Rezoning Transportation Analysis

Petition Number: 2020-083

General Location Identifier: Tax ID 12703702

| Date | Description |
|----------|---------------|
| 01-21-21 | Fifth Review |

RZ-01

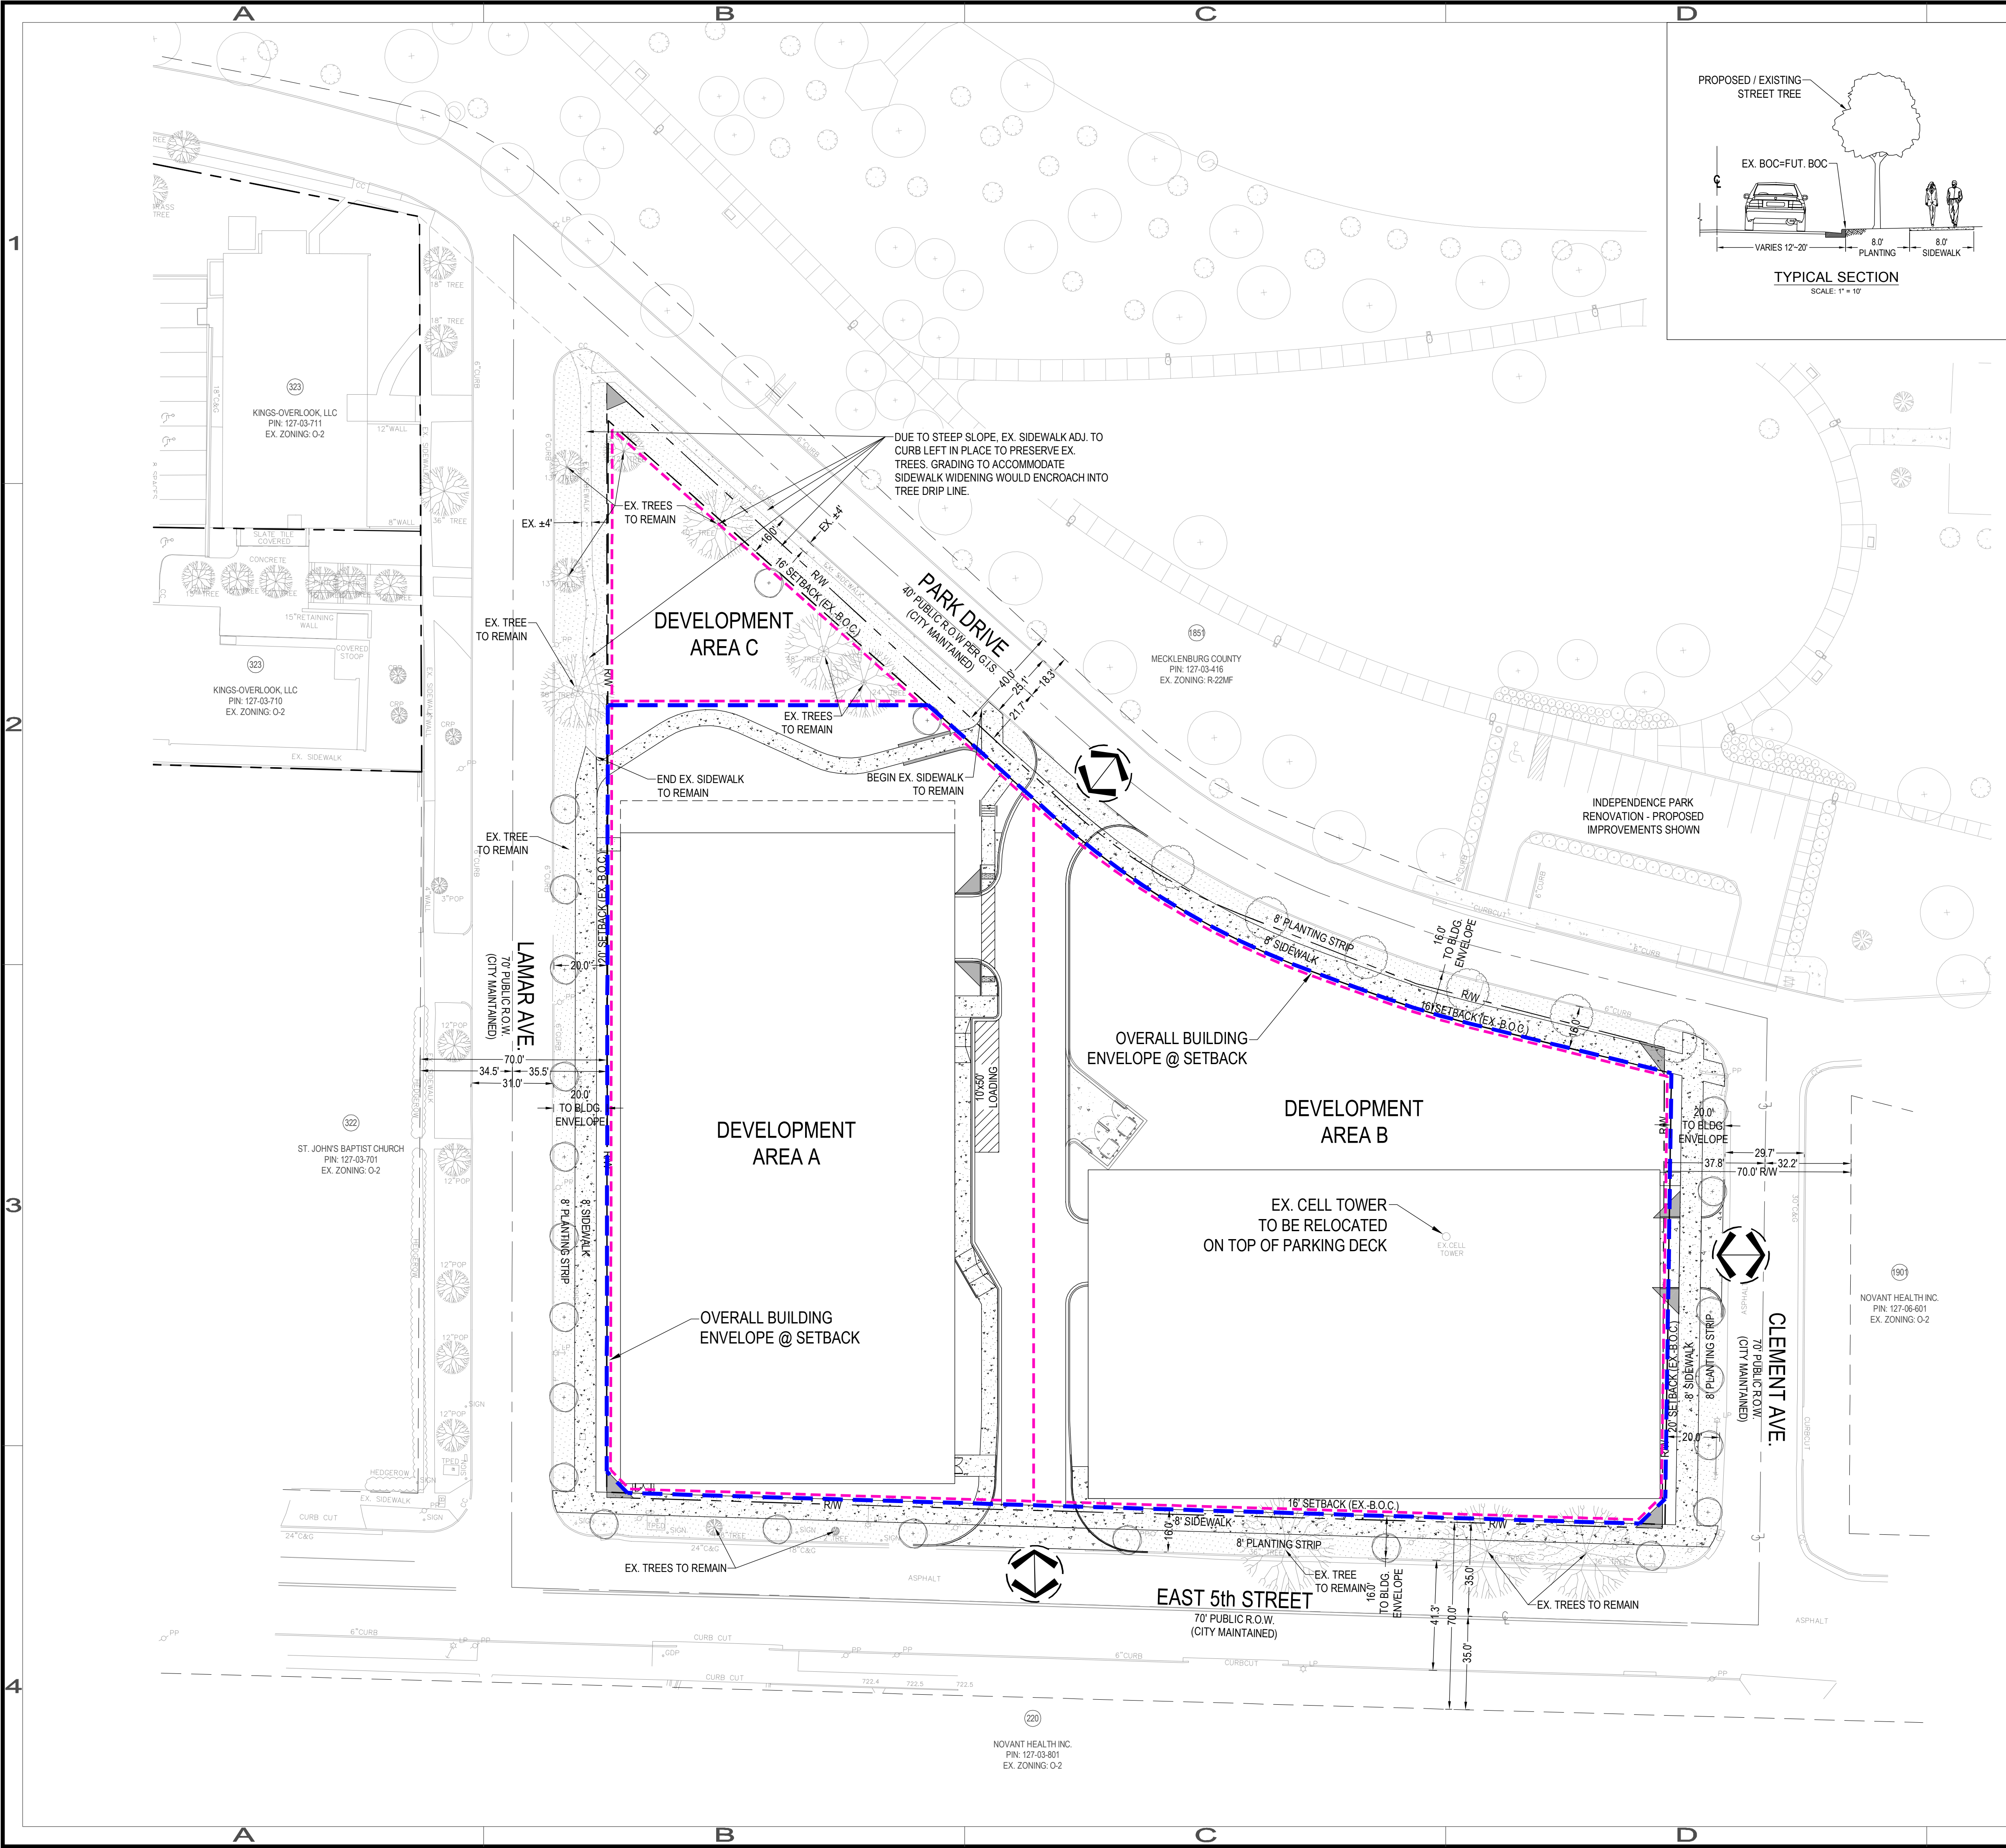
3. **Outstanding:** The petitioner shall revise newly added Conditional Note f. by removing the Greenway and Caswell pedestrian crossing reference. **The petitioner updated Conditional Note f with their January 12, 2021 site plan, but this comment remains outstanding as further revision is needed – remove reference to Greenway and Caswell pedestrian crossing.**

- f. In an effort to further support pedestrian mobility for residents within the Elizabeth area, the Petitioner shall ~~install a pedestrian crosswalk at Greenway and Caswell within the existing road section subject to approval by CDOT. In the event the crosswalk is not approved, the Petitioner shall (y)~~ contribute an amount equal to \$40,000 (the "Ped Improvements Contribution Amount") to the City of Charlotte for the purpose of a pedestrian improvement assessment, design and/or construction of sidewalk, and/or other pedestrian connections in the Elizabeth neighborhood. The Ped Improvements Contribution Amount will be delivered to the City prior to issuance of the first certificate of occupancy for the project contemplated by this Rezoning Petition.

RZ-02

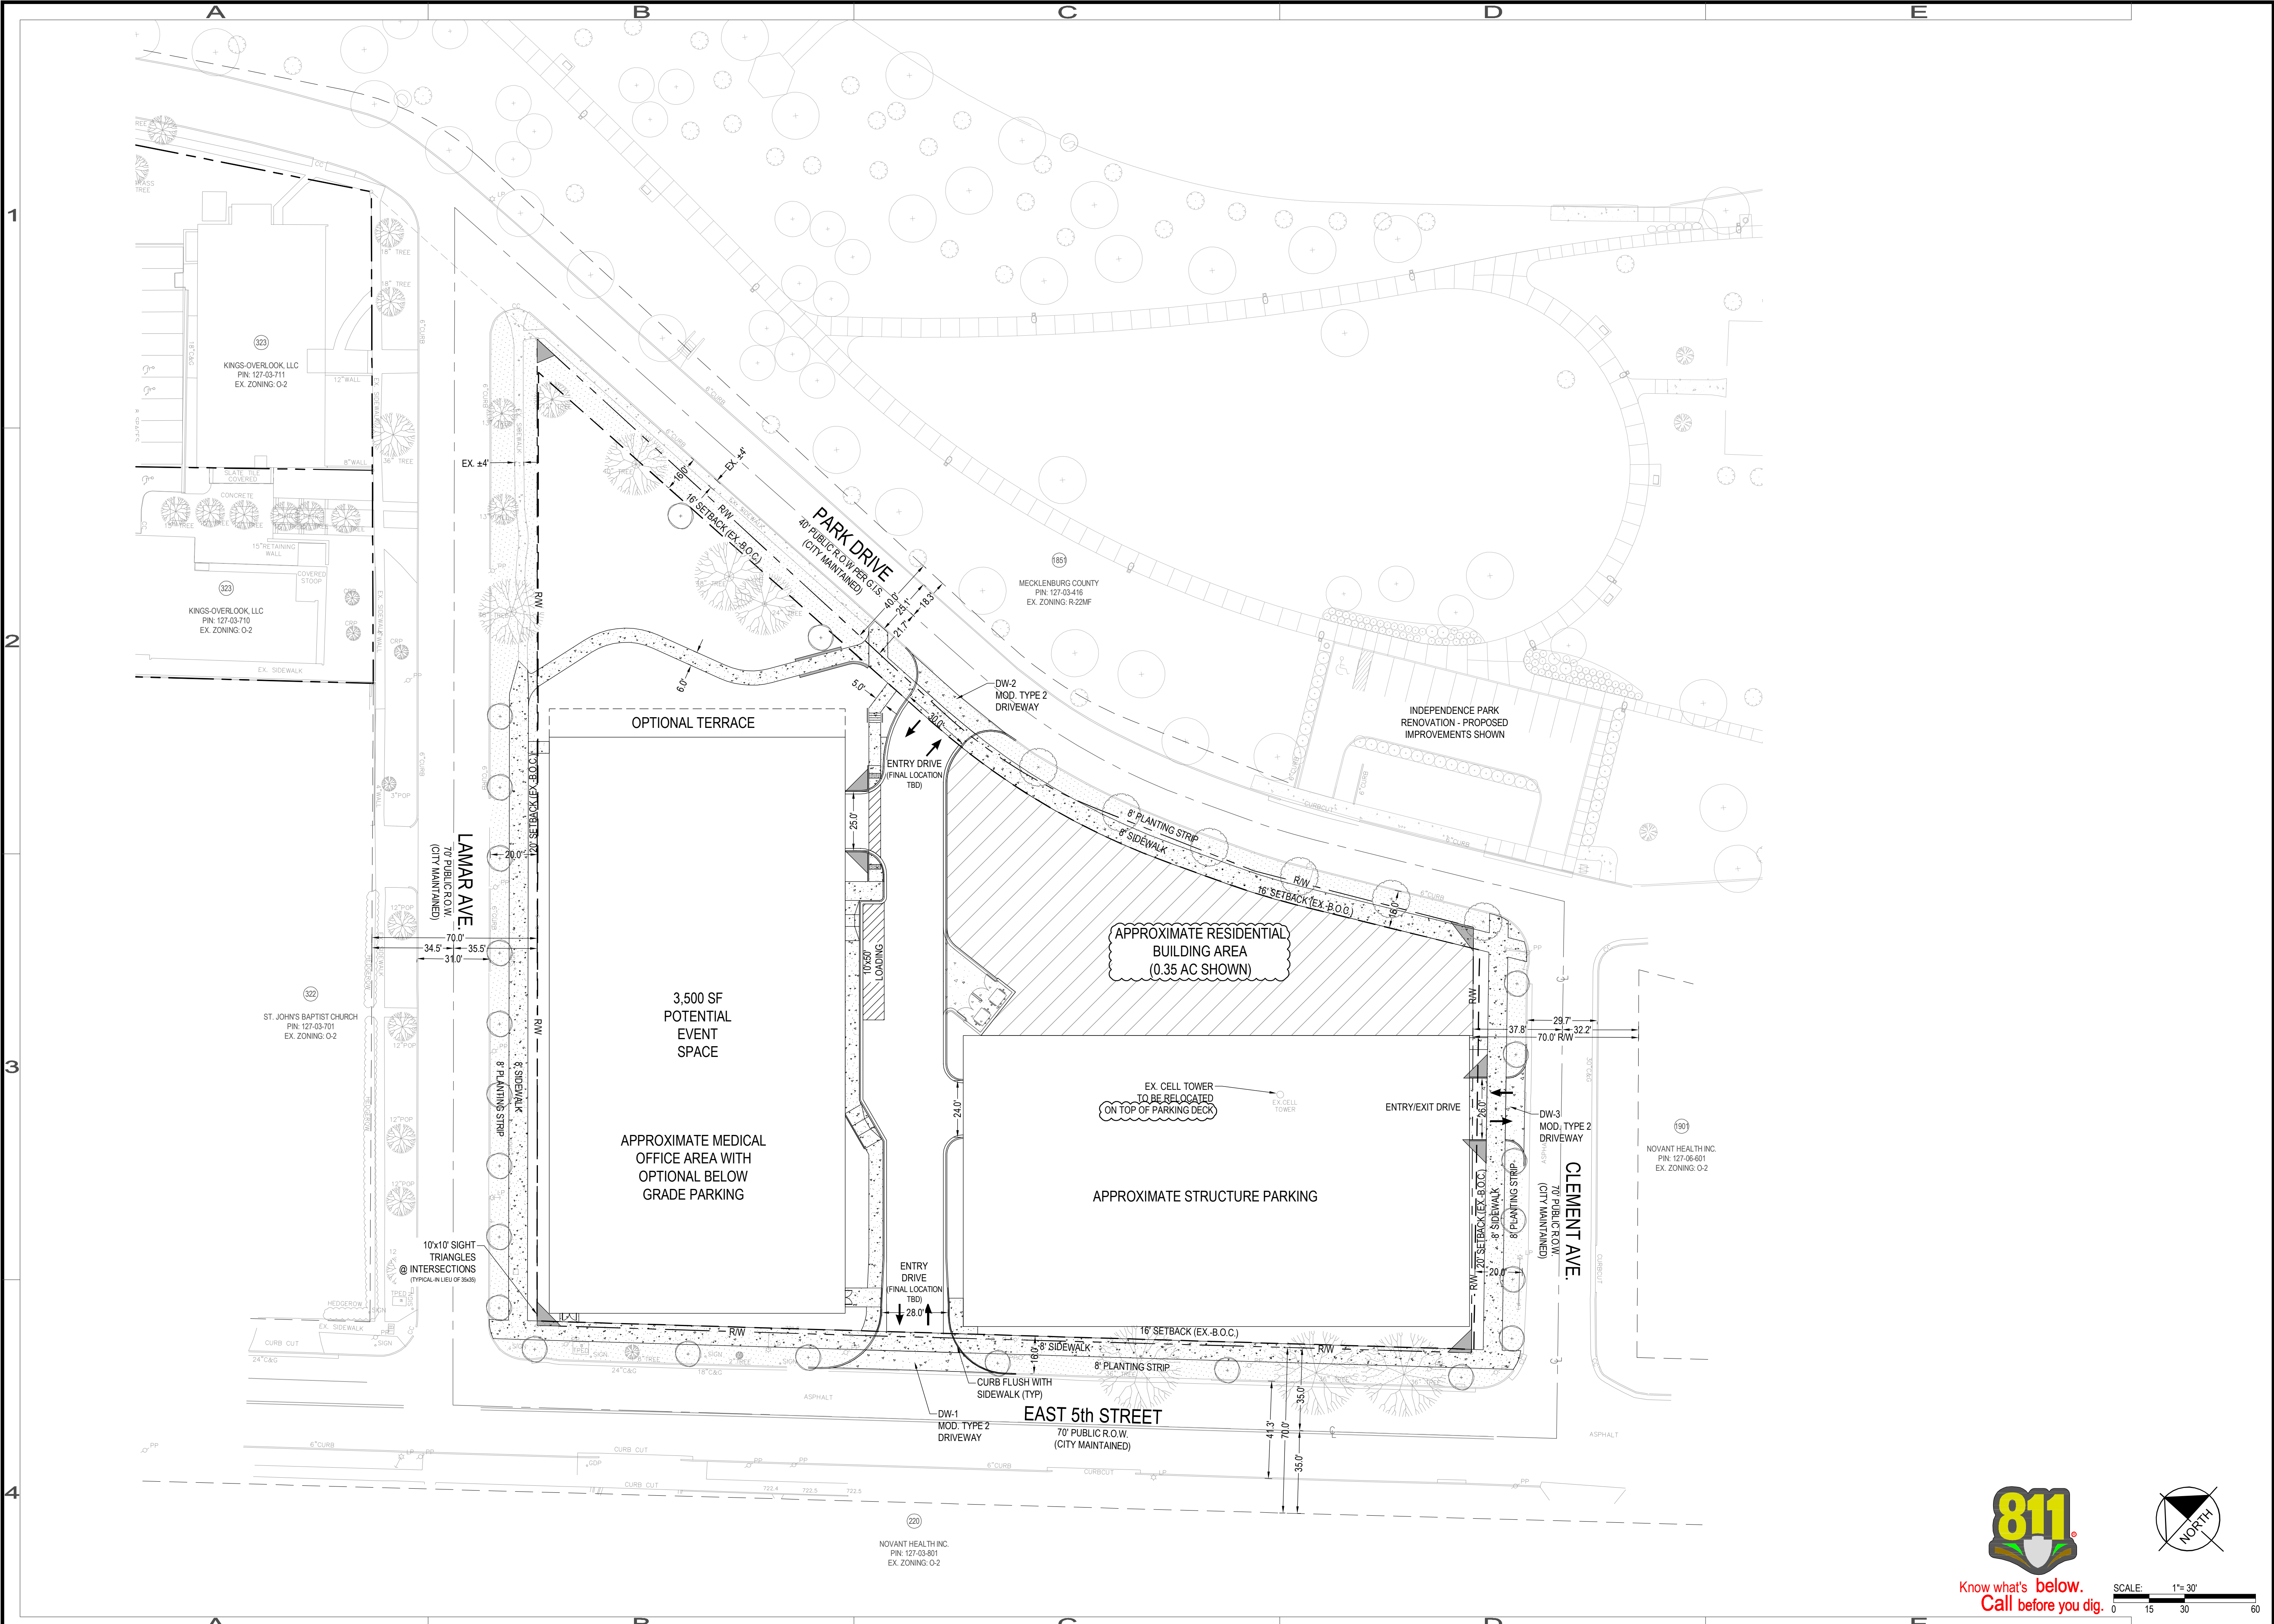
The site plan should show the curb and gutter labeled and dimensioned from the centerline for each road.
